RESPONSE TO SUBMISSIONS: WENTWORTHVILLE NORTHSIDE WEST CLINIC EXTENSION

23-27 LYTTON STREET, WENTWORTHVILLE
LOT 1 DP787784

RESPONSE TO SUBMISSIONS REPORT

SSD-17899480

Drawings: DA0105 indicated 10

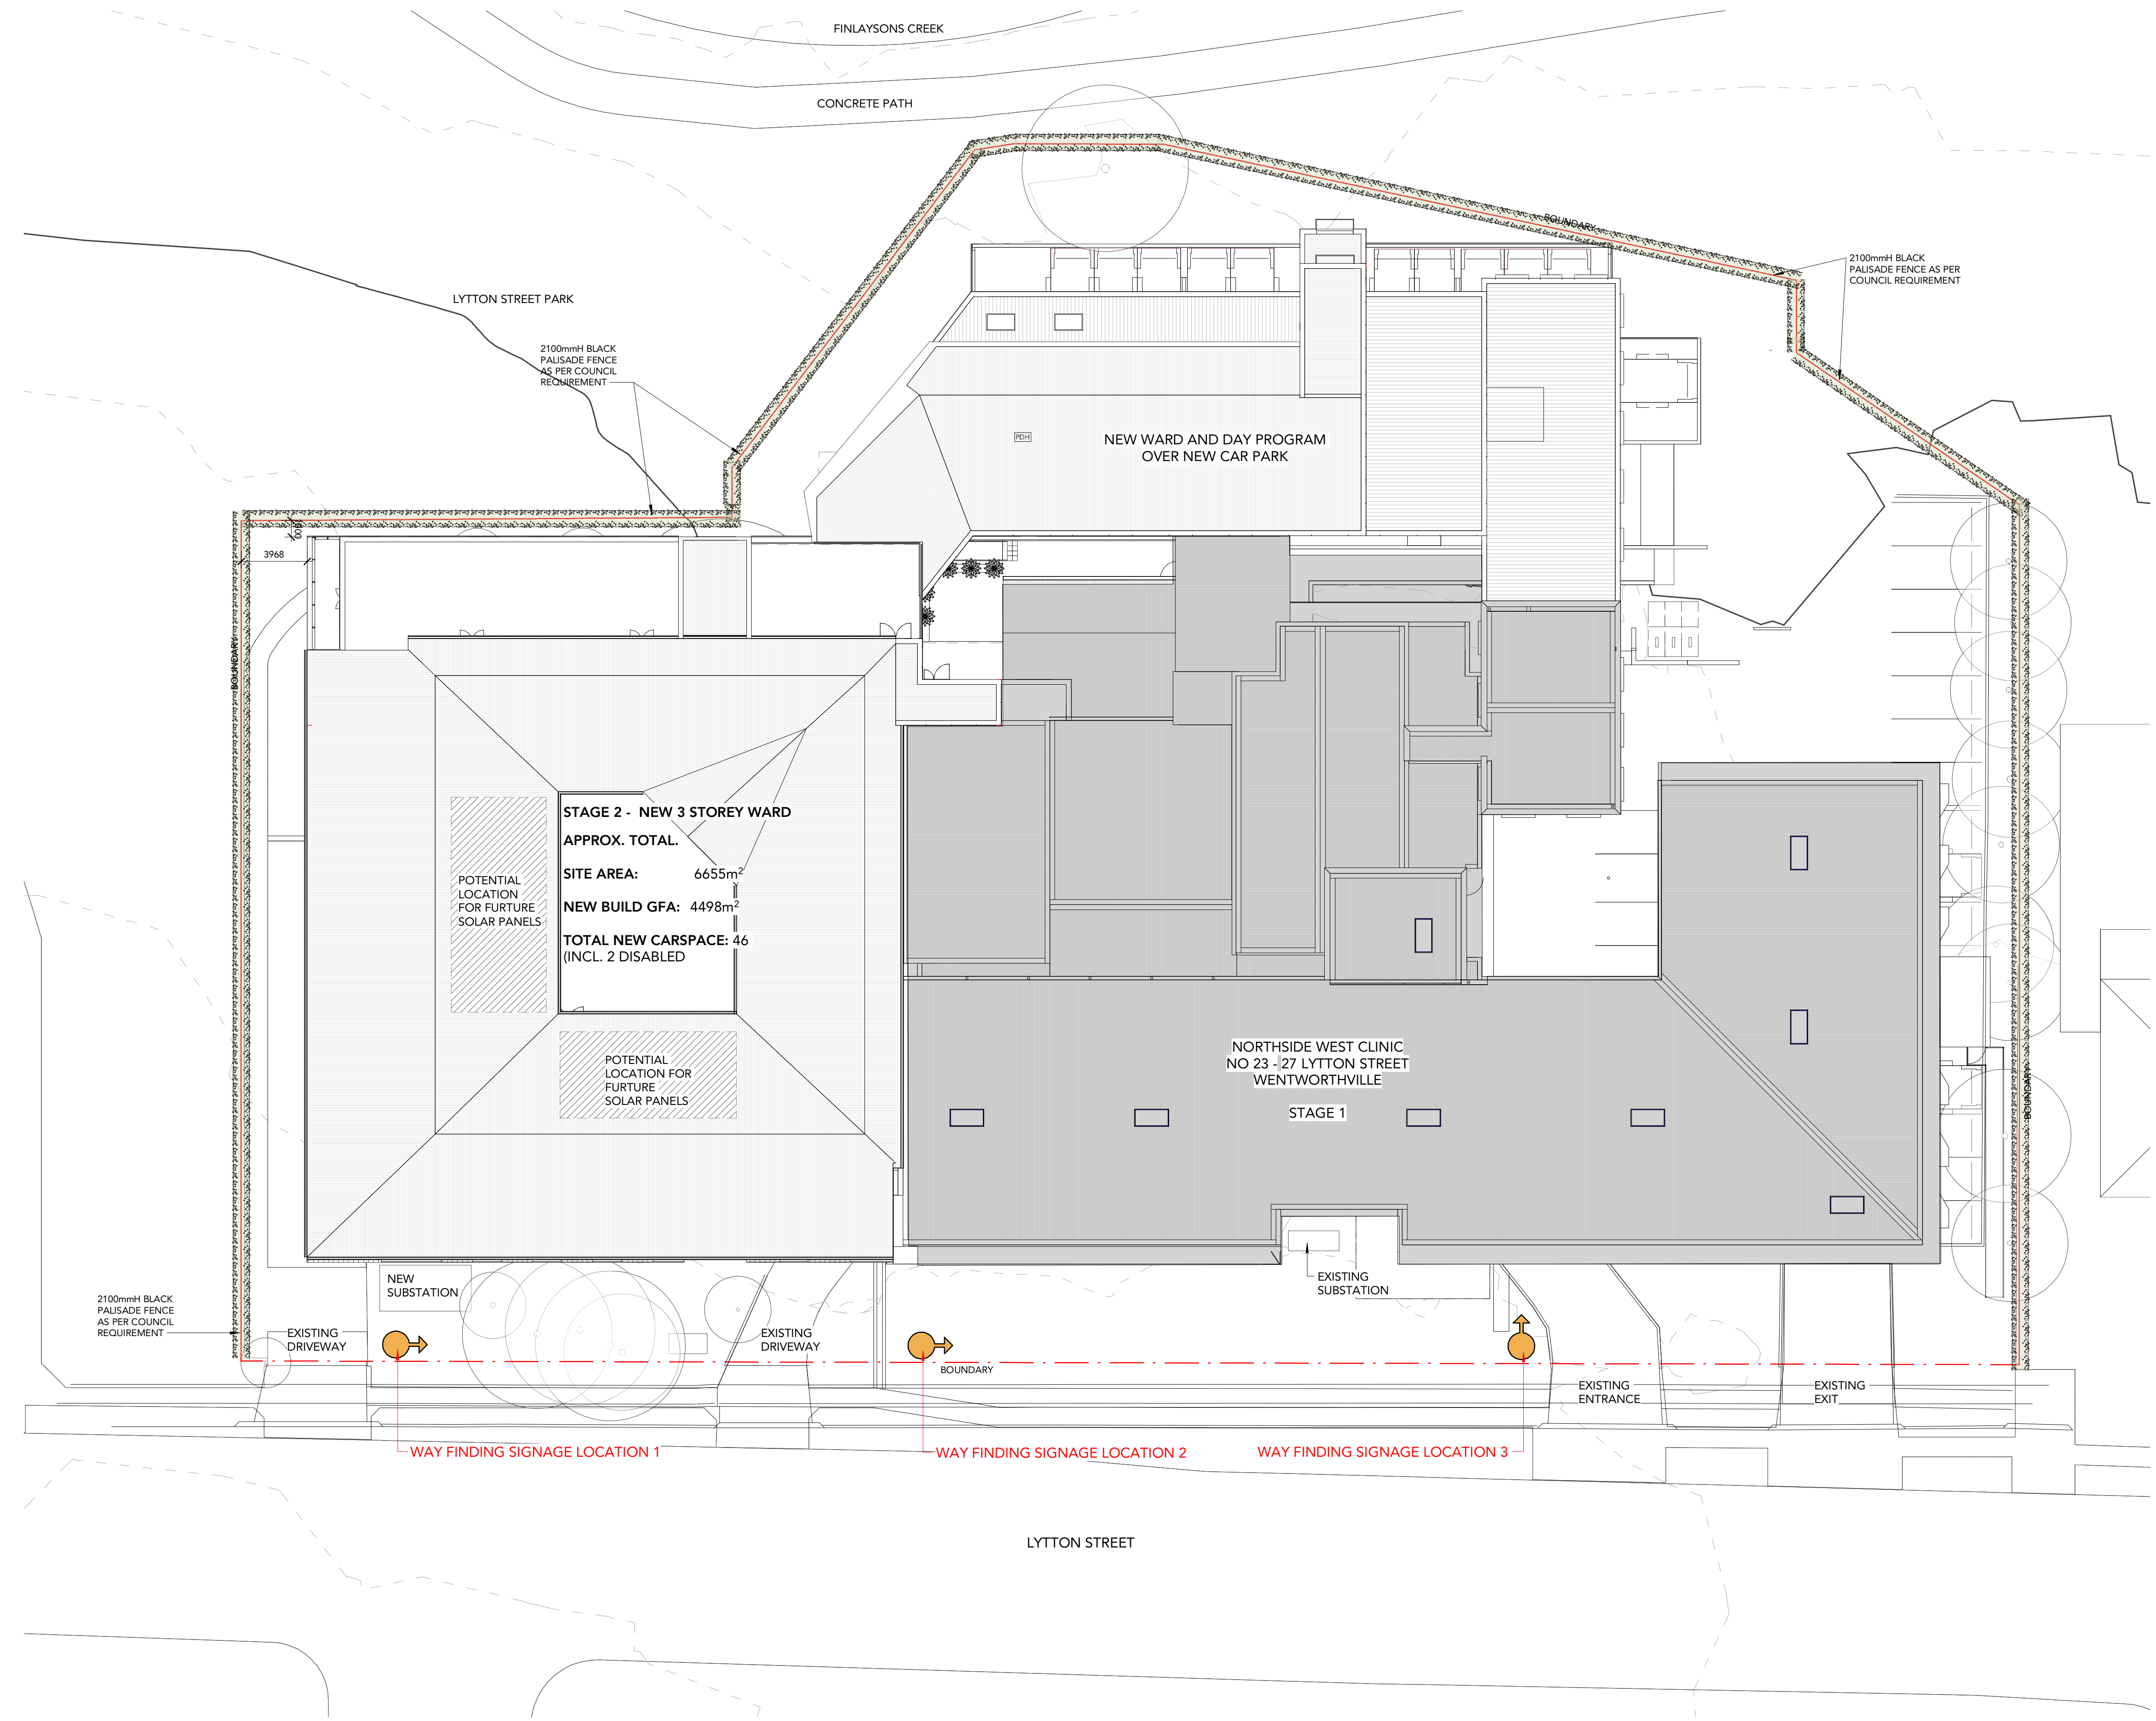
Detail on the architectural plans the location and number of photovoltaics proposed for the development.	Detail is provided on plan 903-DA0105-overall site plan-10 within the Architectural Plans.
	Noise	Update the Noise and Vibration Impact Assessment to include the predicted noise levels for receiver 1 within the noise assessment tables, confirming that the receiver closest to the subject site will not be significantly impacted during	The Noise and Vibration Impact Assessment (Appendix C9) has been updated to include predicted noise levels for Receiver 1 in the noise assessment tables for construction stage.
